Filing No. 1

Updated Traffic Impact Analysis

PCD File No. SF-18-00

Mr. Drew Balsick
Flying Horse North Filing No. 1

FLYING HORSE NORTH FILING NO. 1 STREET IMPROVEMENT PLAN ROUNDABOUT 1 PLAN AND PROFILE PLAN					
DESIGNED BY	PRA	SCALE	DATE 08-11-17		
DRAWN BY	PRA	(H) 1"= 50'	SHEET	26	OF 58
CHECKED BY	(V)	1"= 5'	JOB NO.	1096.11

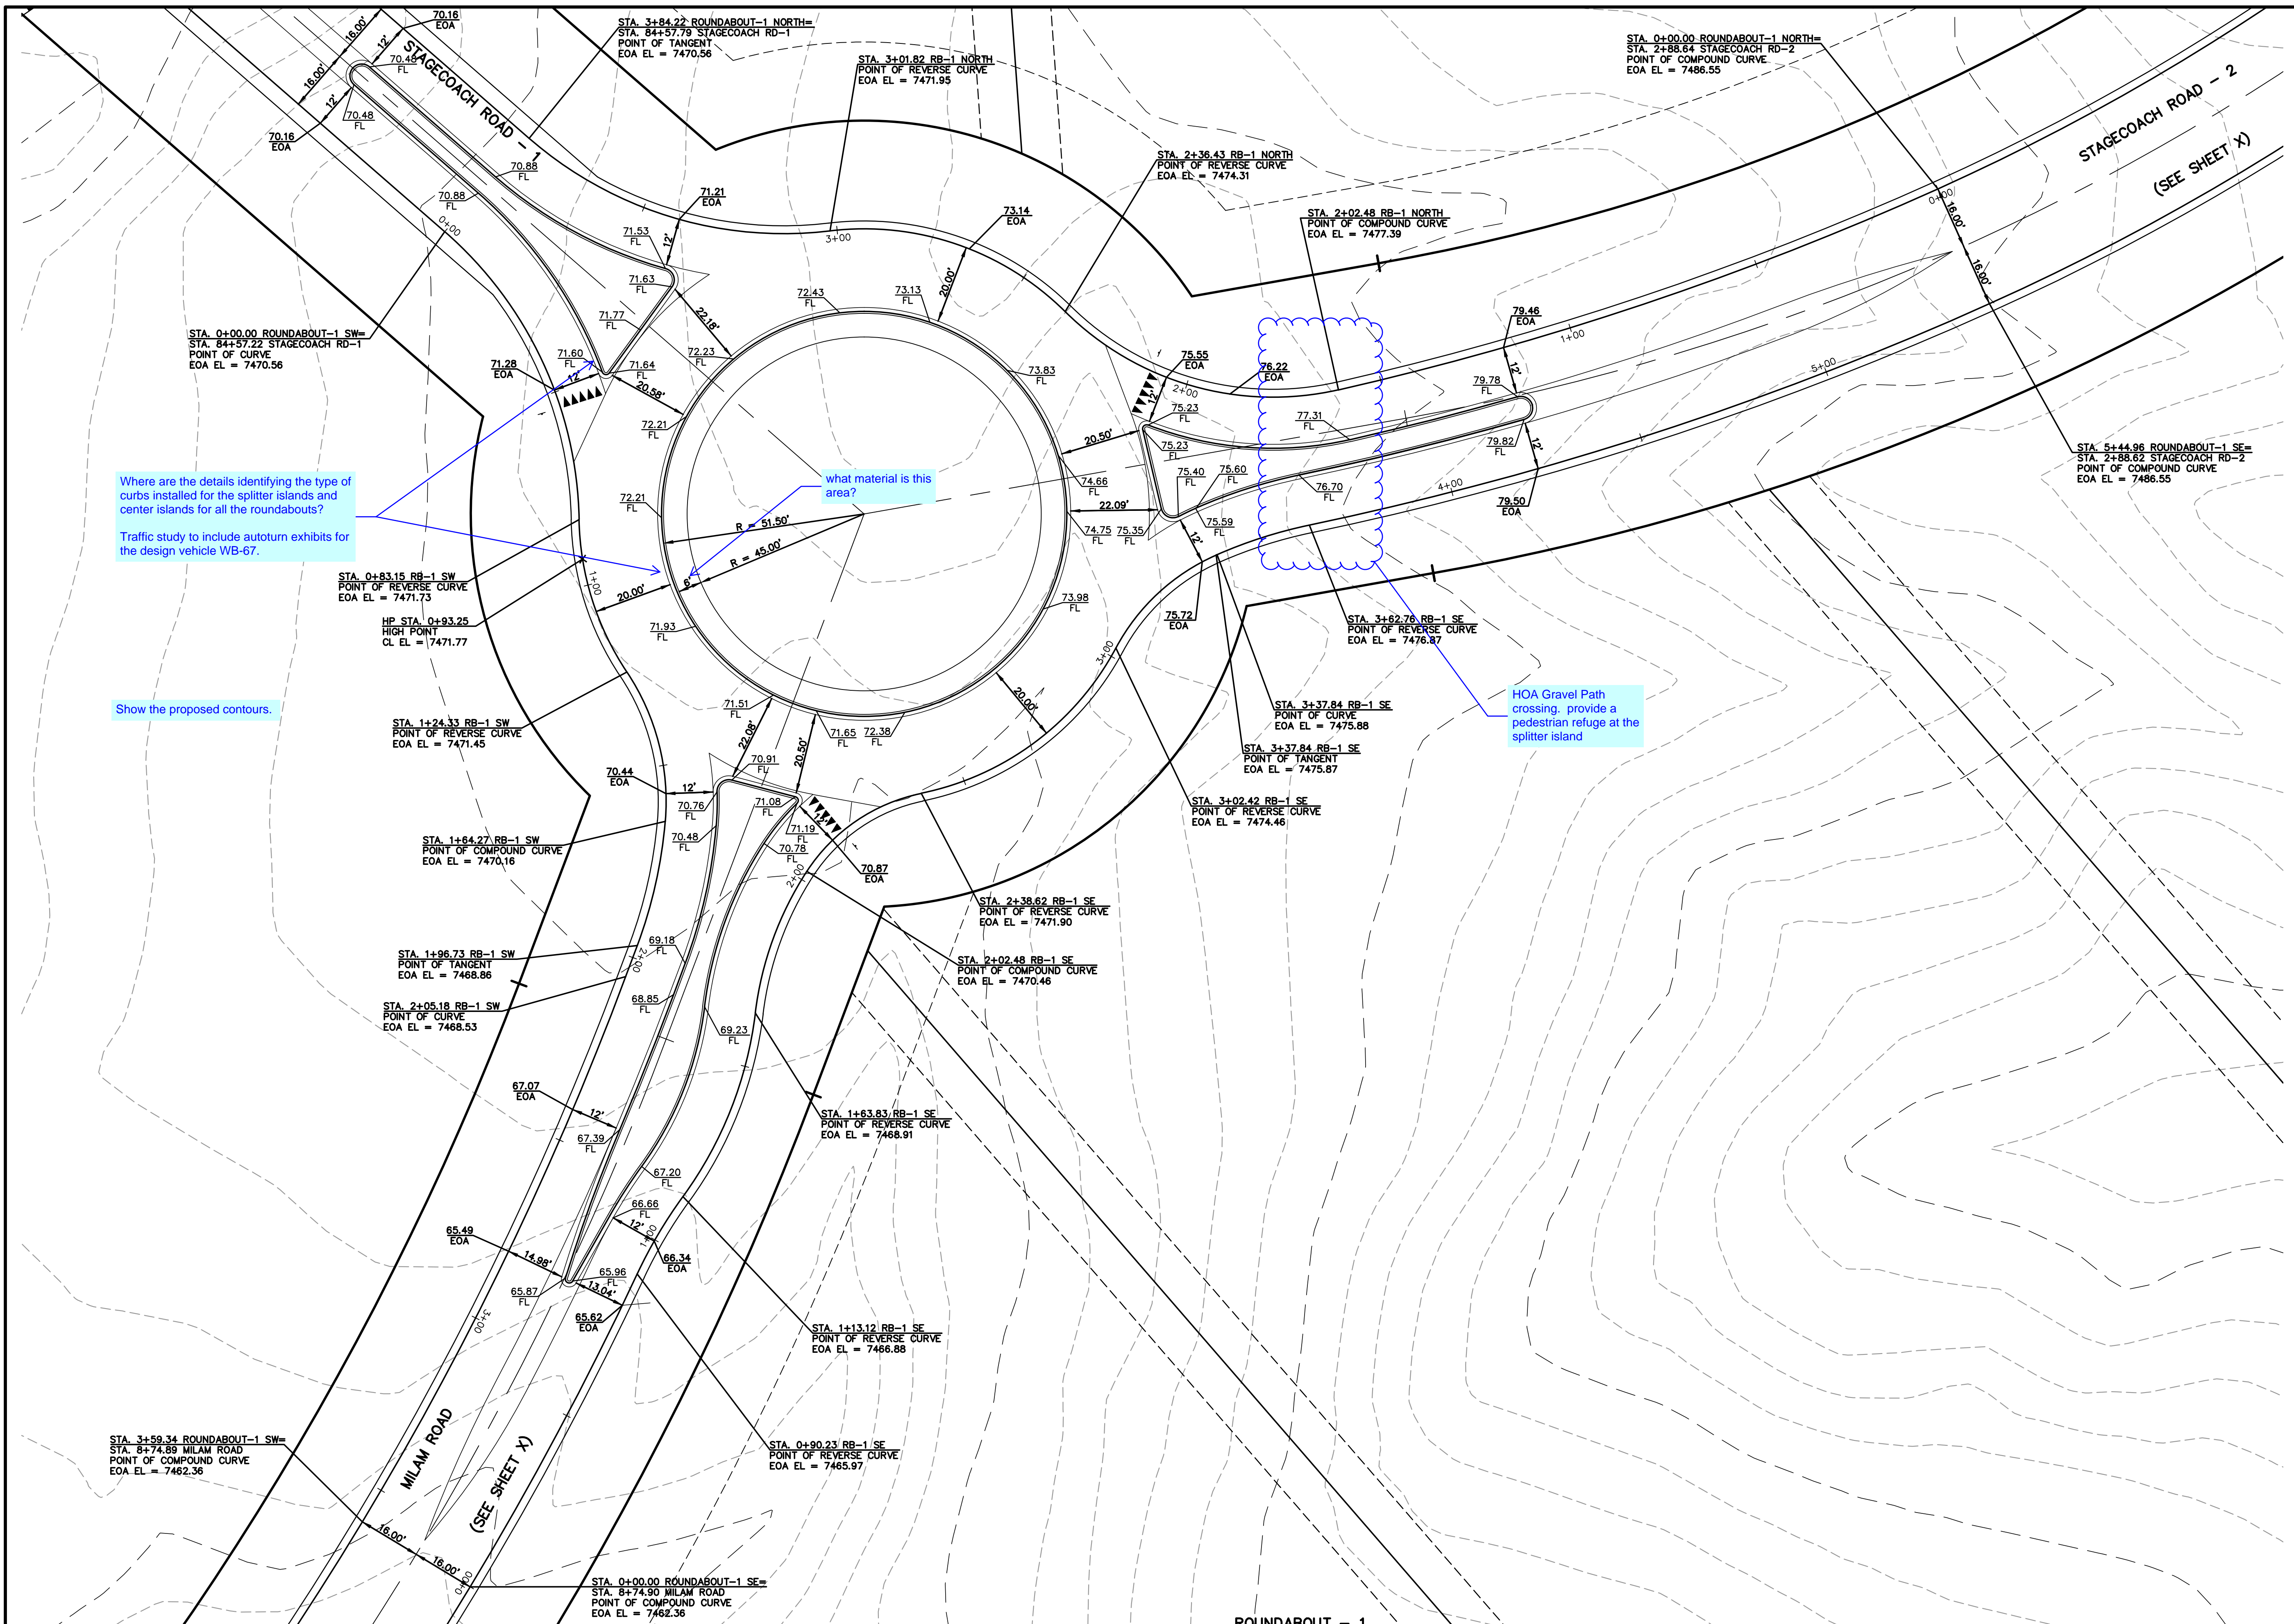
³ Include autoturn exhibits of WB-67 trucks at each roundabout.

Include autoturn exhibits of WB-67 trucks at each roundabout.

⁴ Please refer to the responses to the construction drawing comments. The roundabout design was completed by Classic Consulting. A note to this effect has been added to the update TIS.

Please refer to the responses to the construction drawing comments. The roundabout design was completed by Classic Consulting. A note to this effect has been added to the update TIS.

N:\09611\DRAWINGS\CONSTRUCTION\109611-SI-37.dwg, 12/15/2017 7:50:41 AM, DWG To PDF.pc3

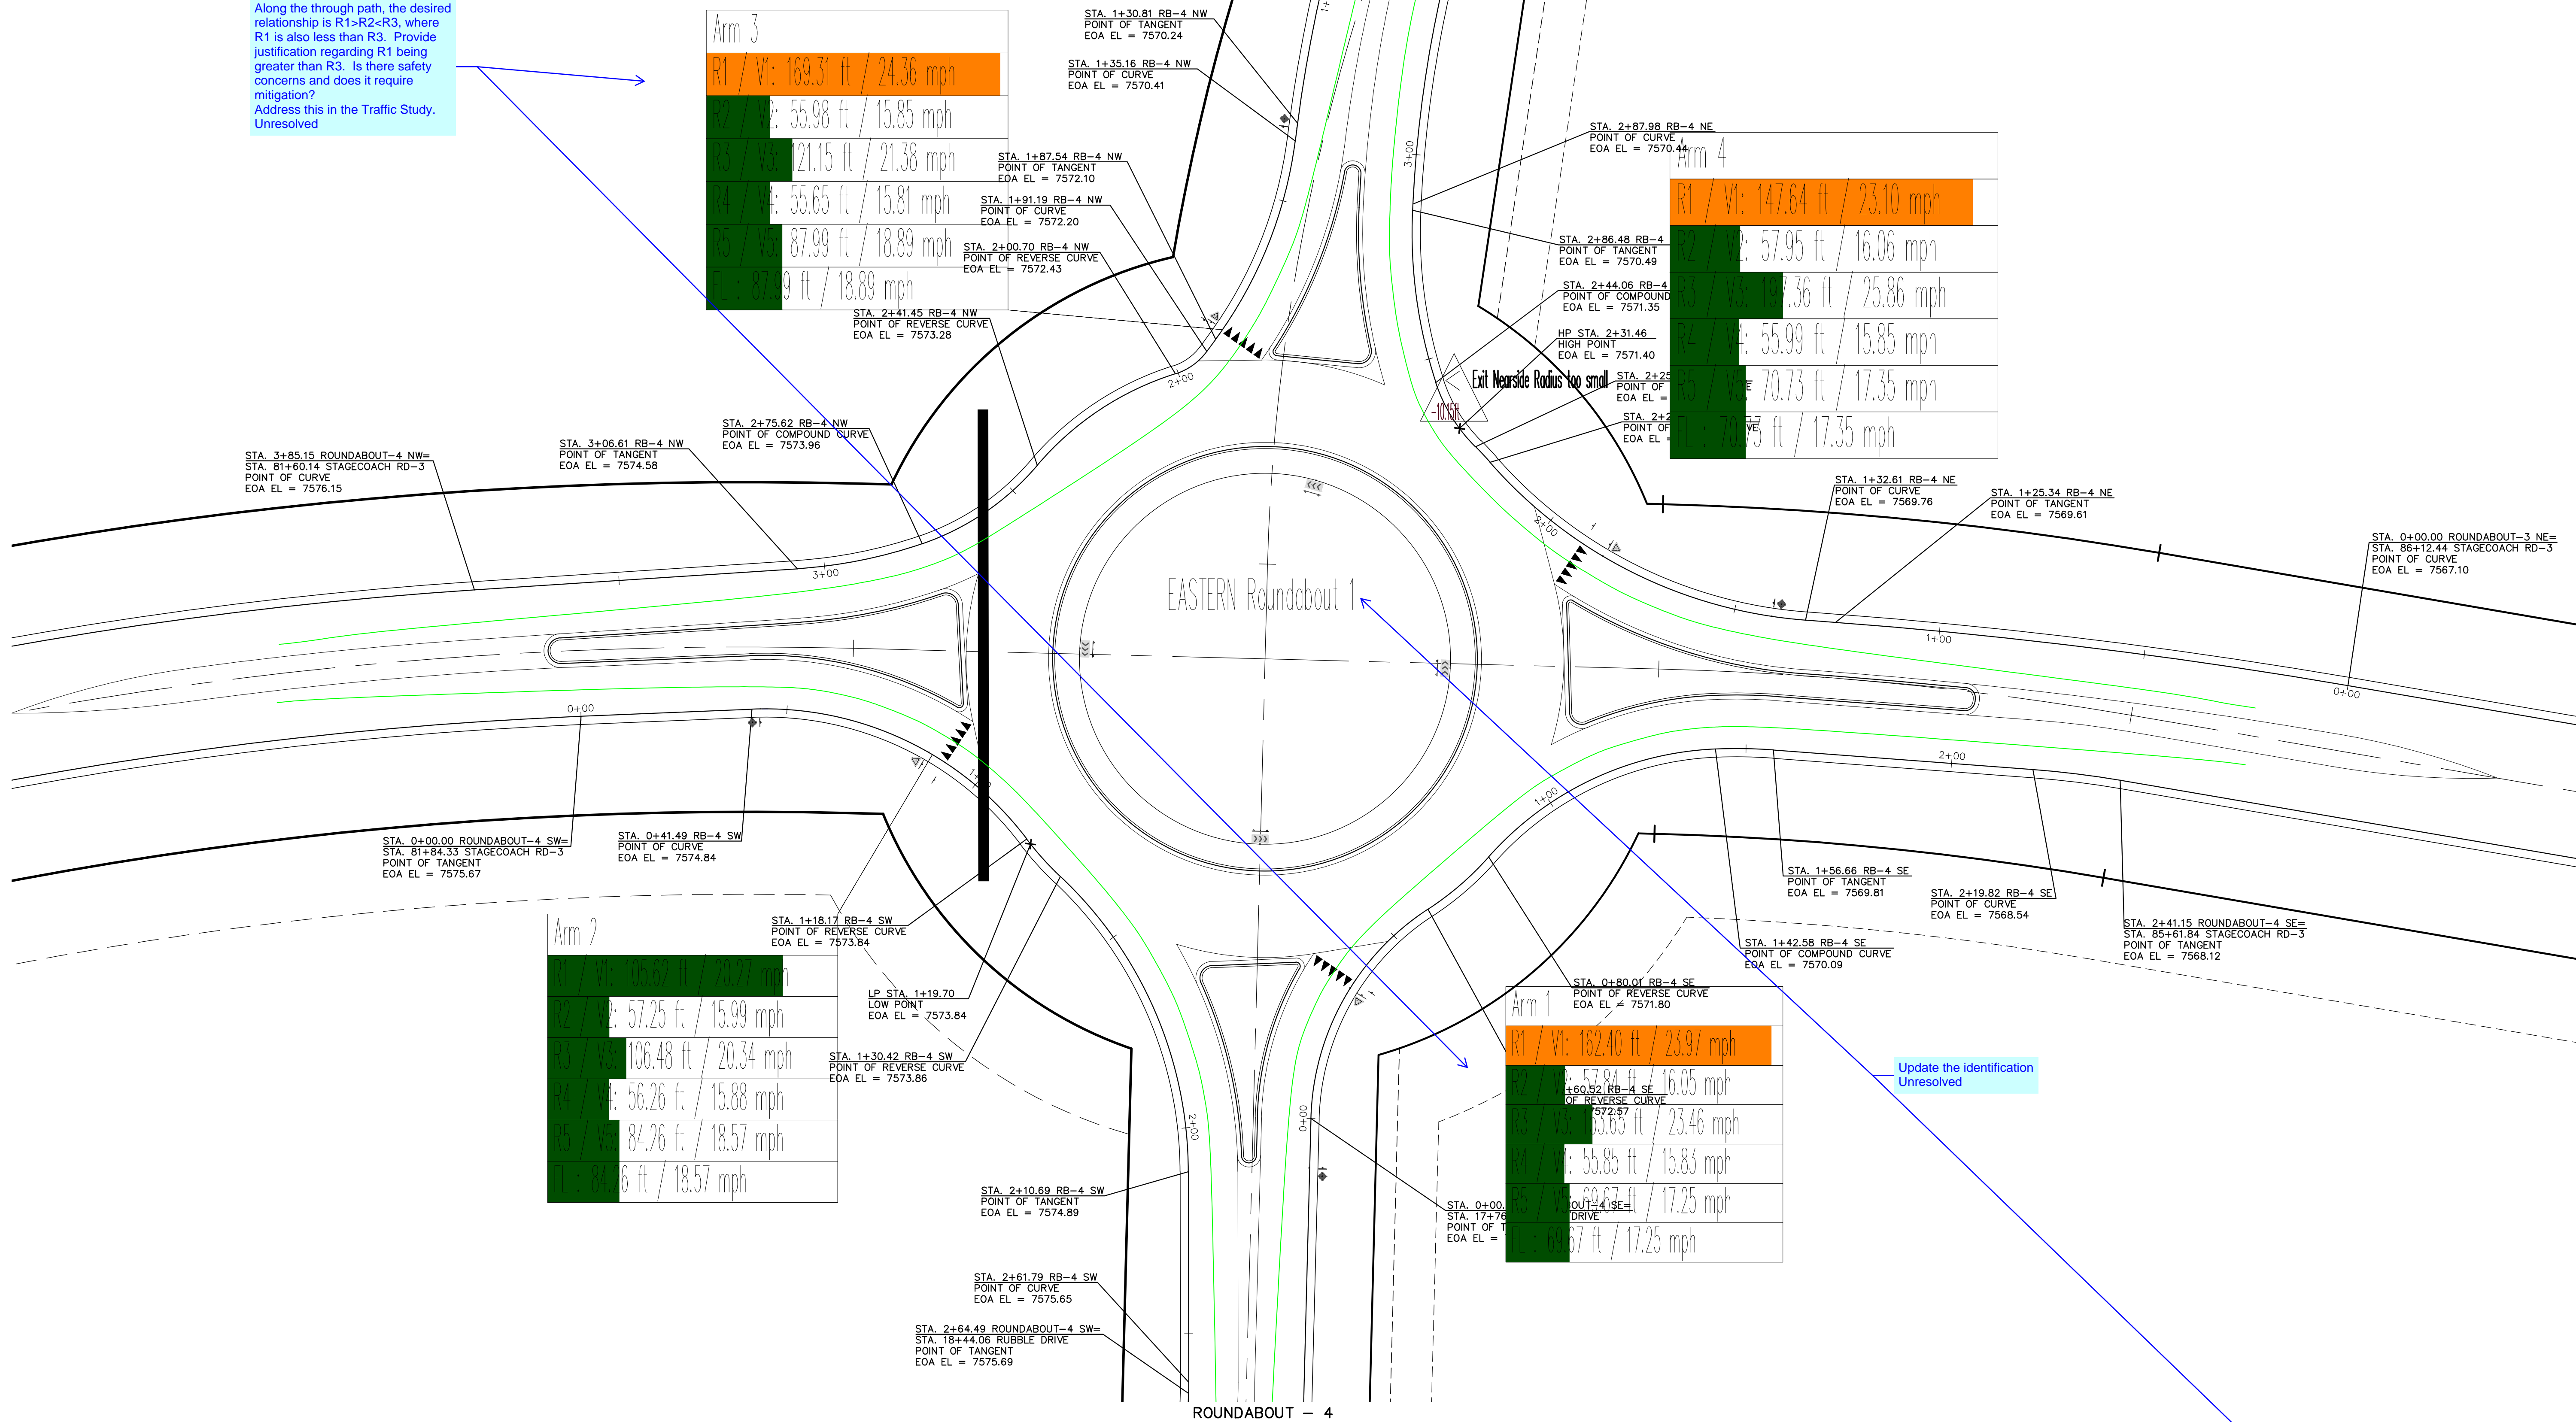
¹ Along the through path, the desired relationship is $R1 > R2 < R3$, where R1 is also less than R3. Provide justification regarding R1 being greater than R3. Is there safety concerns and does it require mitigation?
Address this in the Traffic Study.
Unresolved. This is a comment made in sheet 37 of the construction drawings.

Along the through path, the desired relationship is $R1 > R2 < R3$, where $R1$ is also less than $R3$. Provide justification regarding $R1$ being greater than $R3$. Is there safety concerns and does it require mitigation? Address this in the Traffic Study. **Unresolved. This is a comment made in sheet 37 of the construction drawings.**

² Please refer to the responses to the construction drawing comments. The roundabout design was completed by Classic Consulting. A note to this effect has been added to the update TIS.

Please refer to the responses to the construction drawing comments. The roundabout design was completed by Classic Consulting. A note to this effect has been added to the update TIS.
